29 May 2026
Ref 25332

SSD-97528708
PROPOSED MIXED-USE DEVELOPMENT
13 GIPPS STREET, 6 SHADFORTH STREET &
142-148, 160 OXFORD STREET, PADDINGTON
TRAFFIC & PARKING MATTERS

I refer to Woollahra Municipal Council's letter dated 16 March 2026 requesting additional information in respect of the abovementioned development proposal.

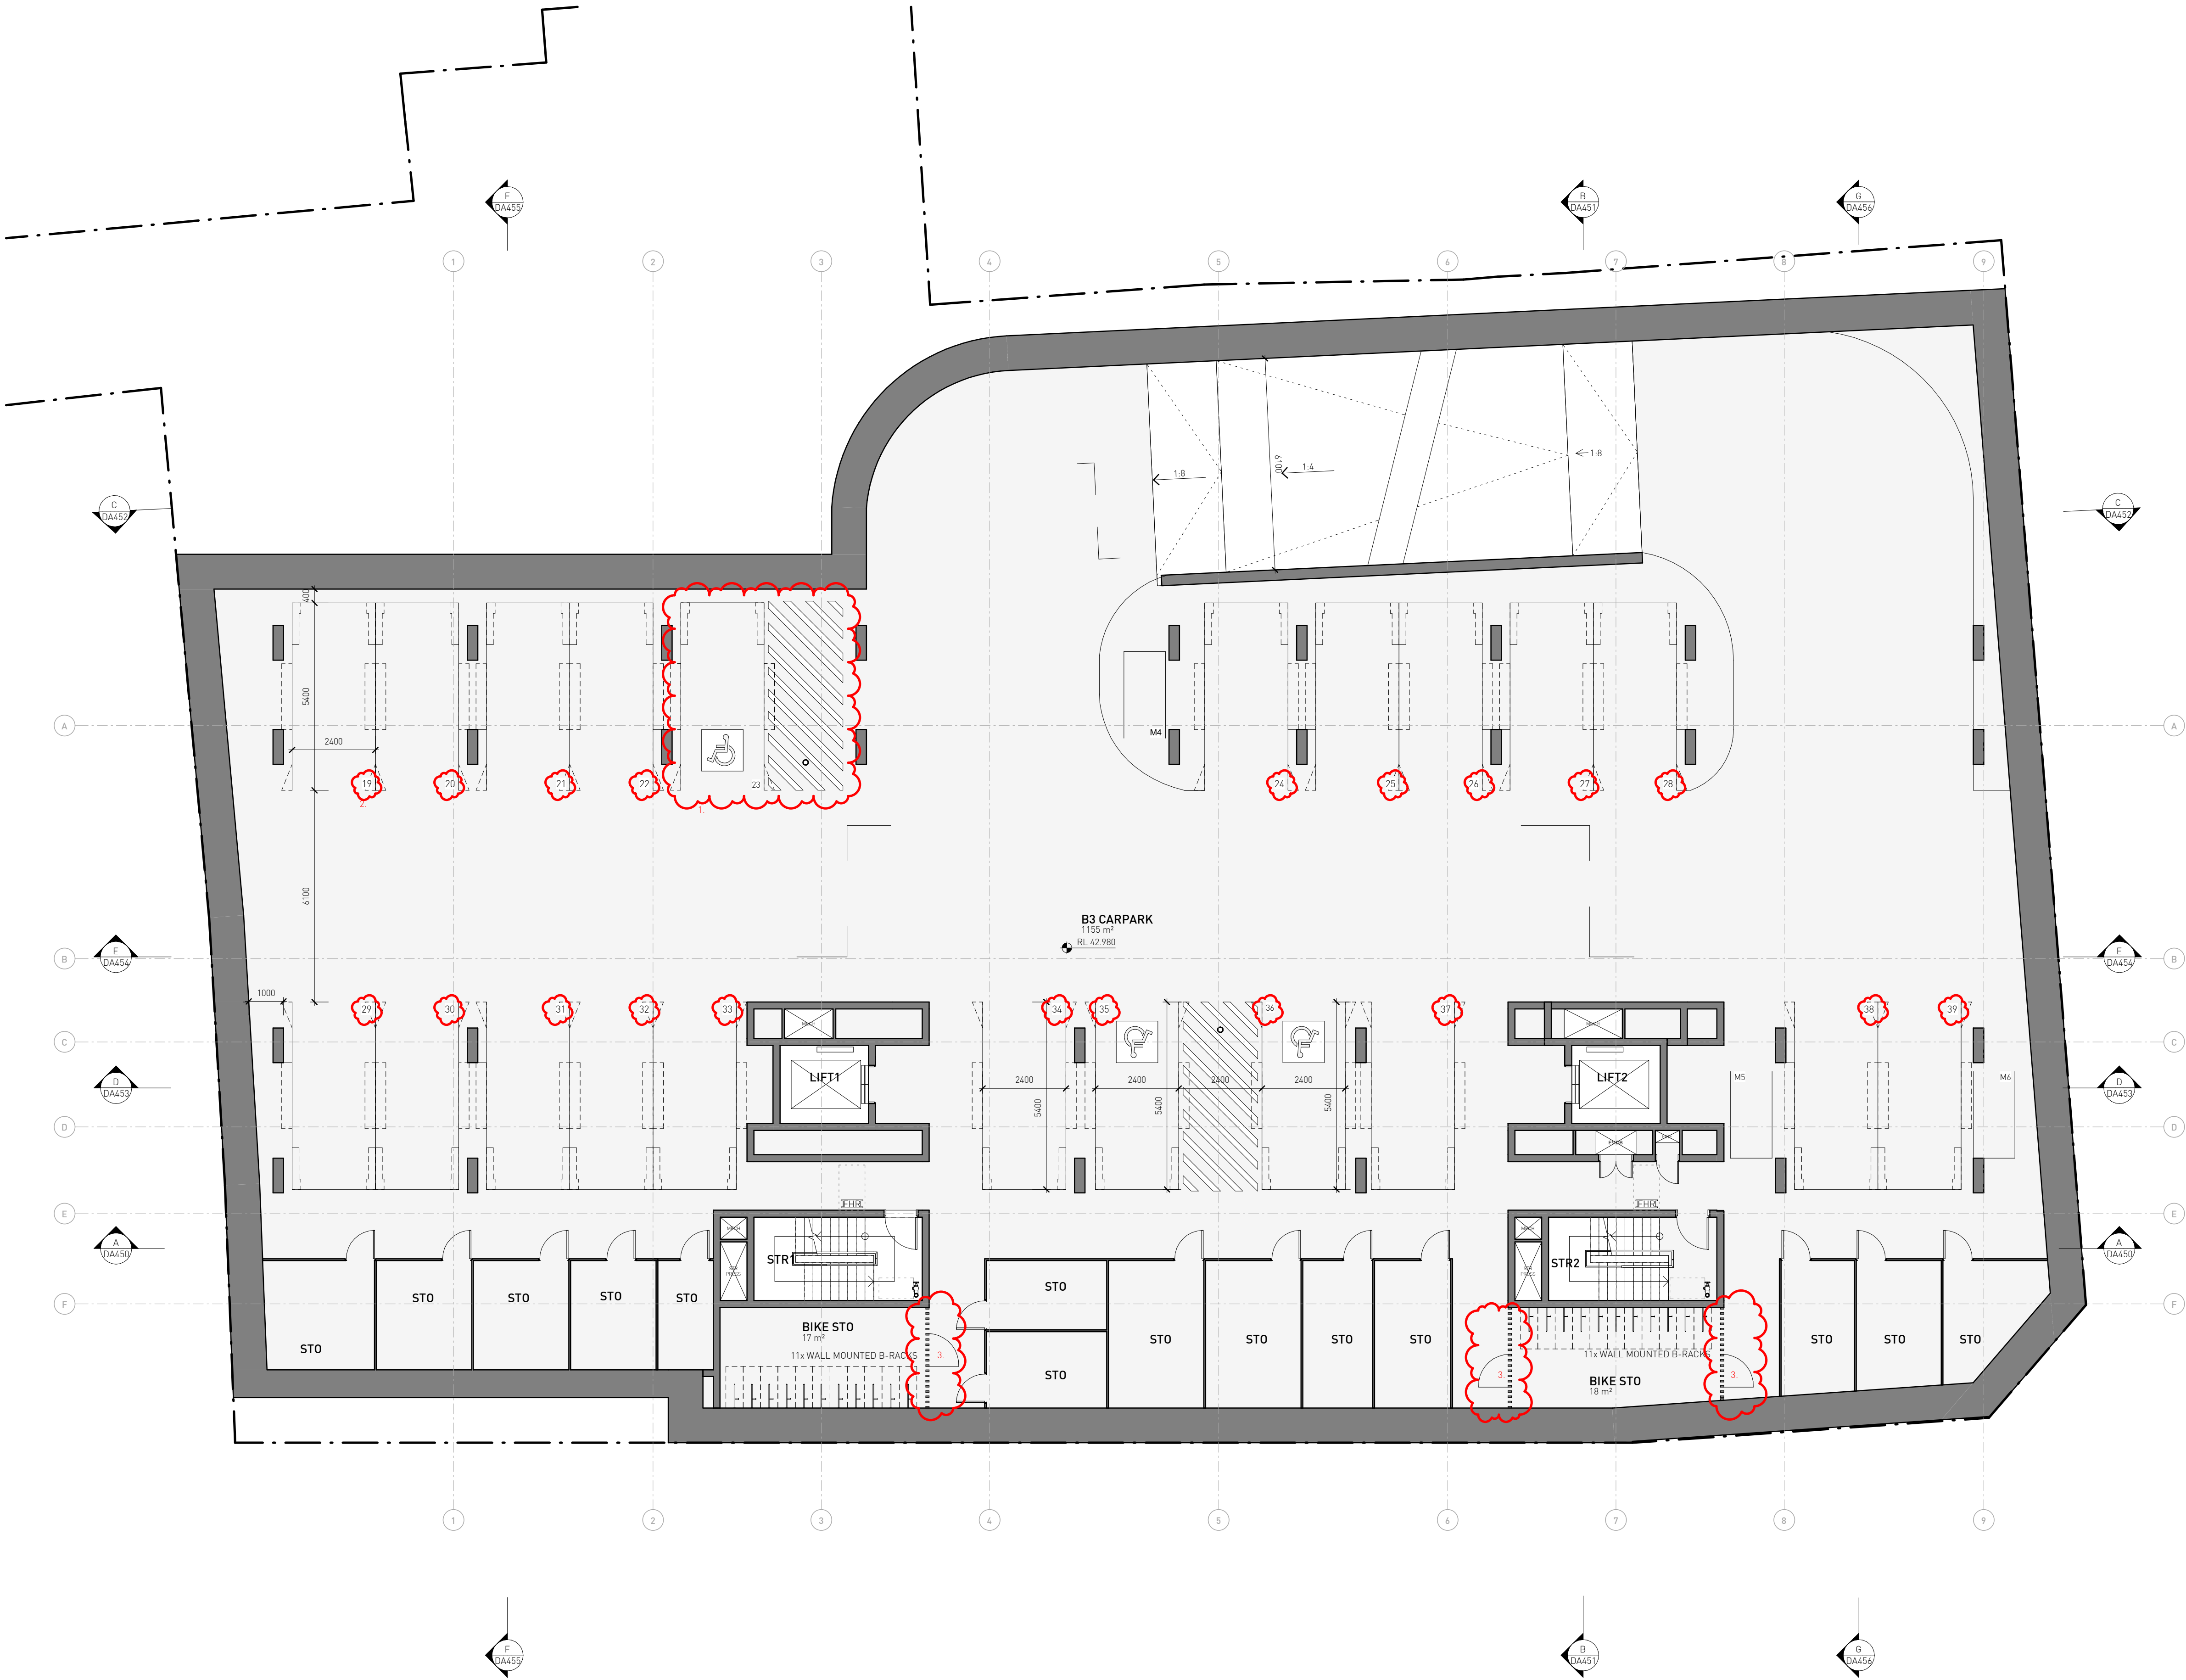
In response, the proposed development makes provision for a total of 82 off-street car parking spaces (including 5 accessible car spaces), comprising 67 residential spaces, 9 visitor spaces, and 6 retail spaces, thereby satisfying the *SEPP (Housing) 2021* and *TfNSW Guide minimum* car parking requirements.

DRAWING TITLE
12.5M HRV SWEEP TURNING PATHS
Entering Shadforth Street from Liverpool Street

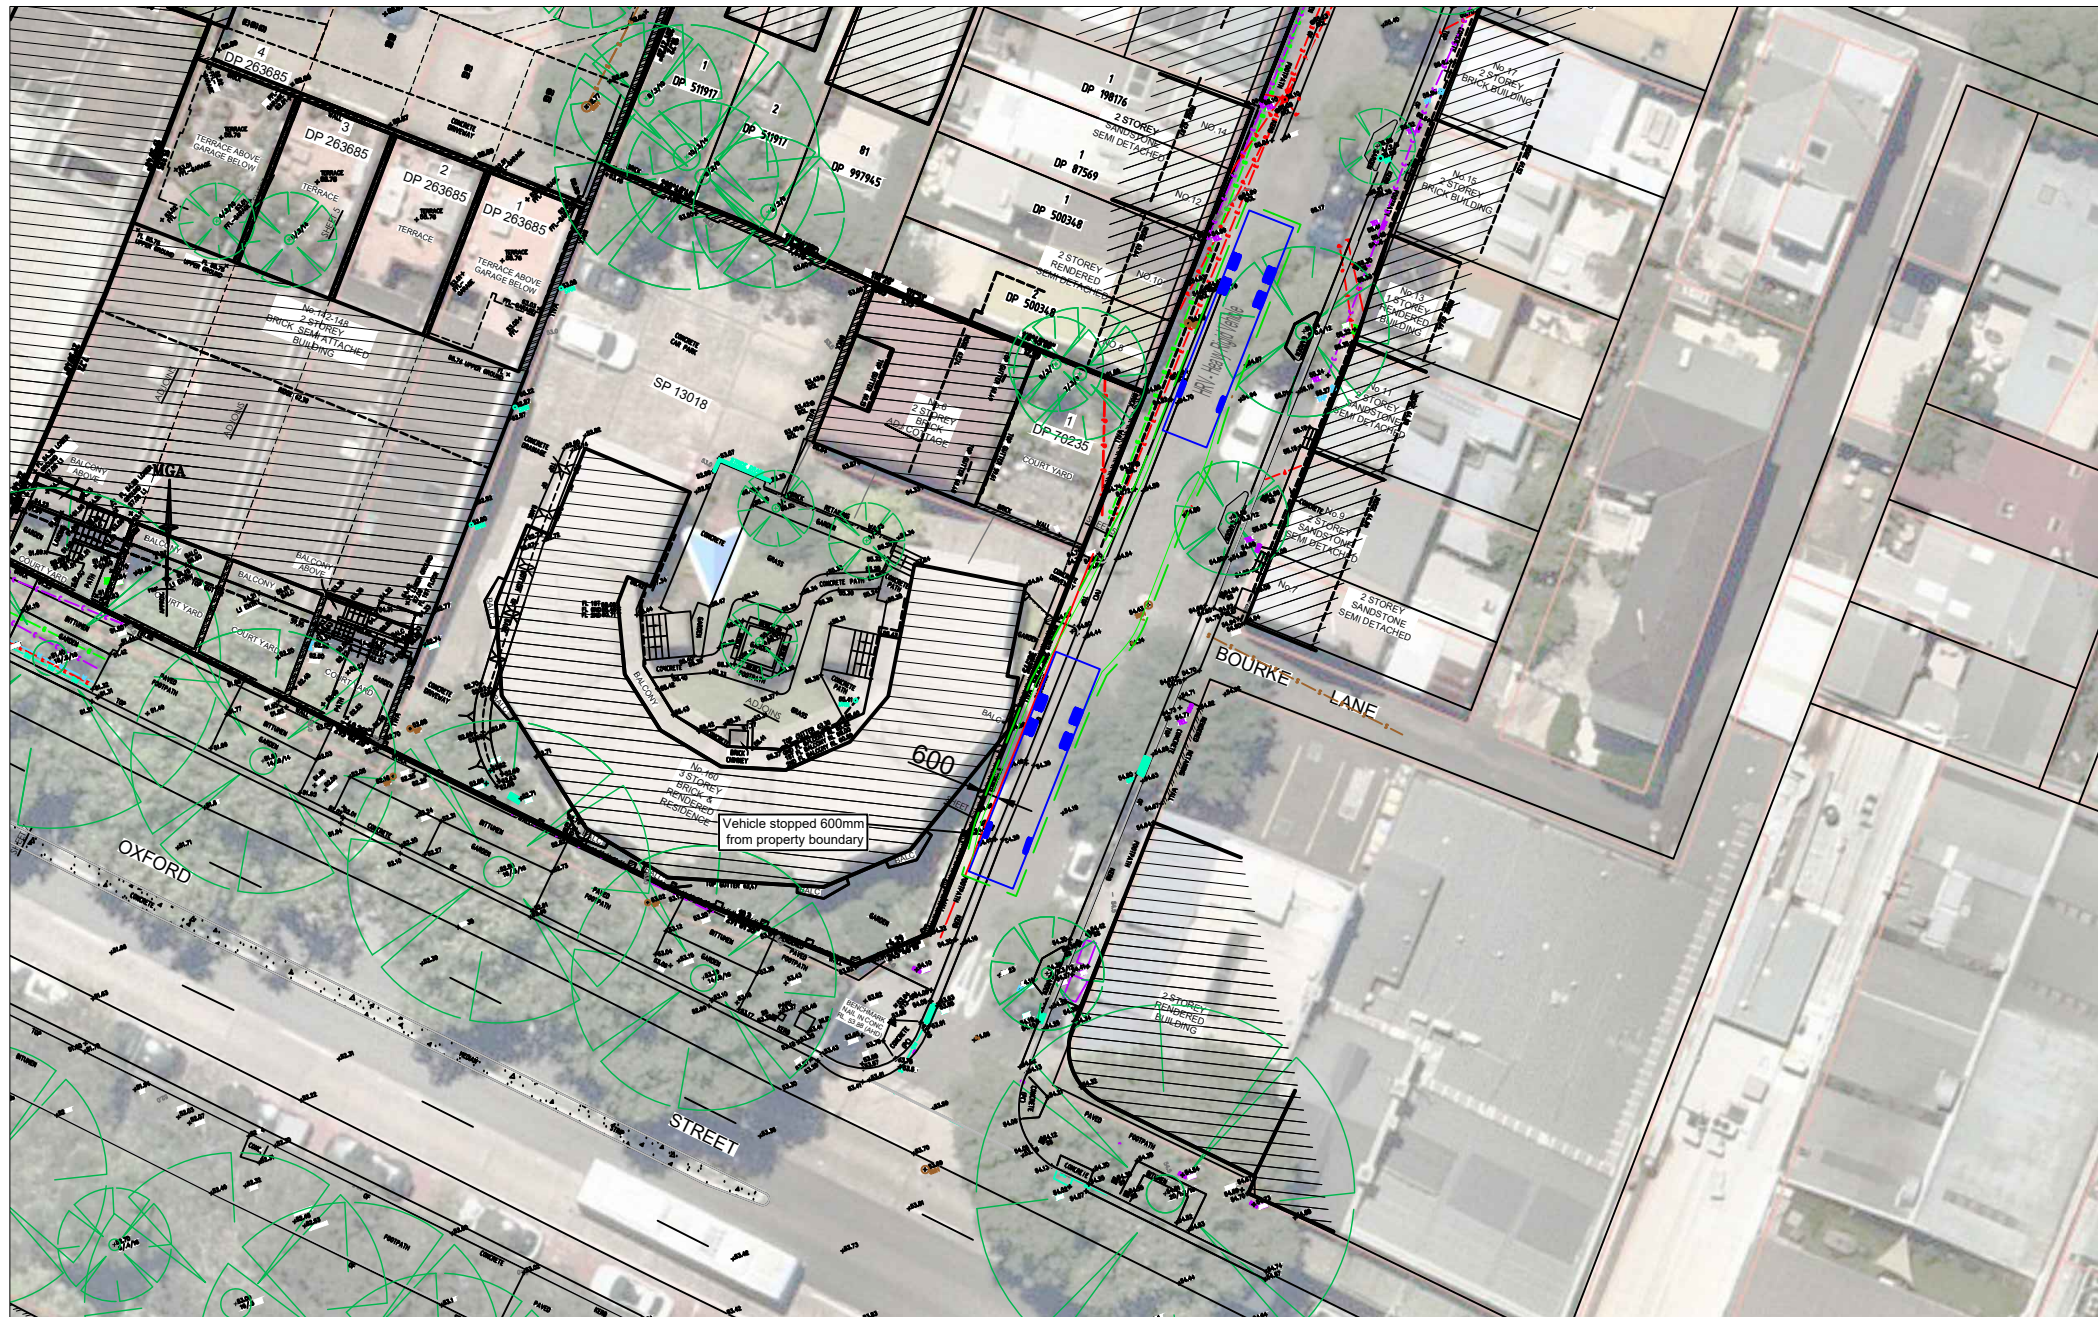
The amended Works Zone will accommodate access by 12.5m long HRV trucks, which will approach the site via Glenmore Road, Liverpool Street, then Shadforth Street, and will leave the site via Oxford Street.

The suggestion by Council that vehicles attending the site via Shadforth Street should be reduced to 6.4m long SRV trucks "to minimize local impacts" would, in fact, have the opposite effect, because using the smaller truck would require a commensurate increase in the number of truck movements.
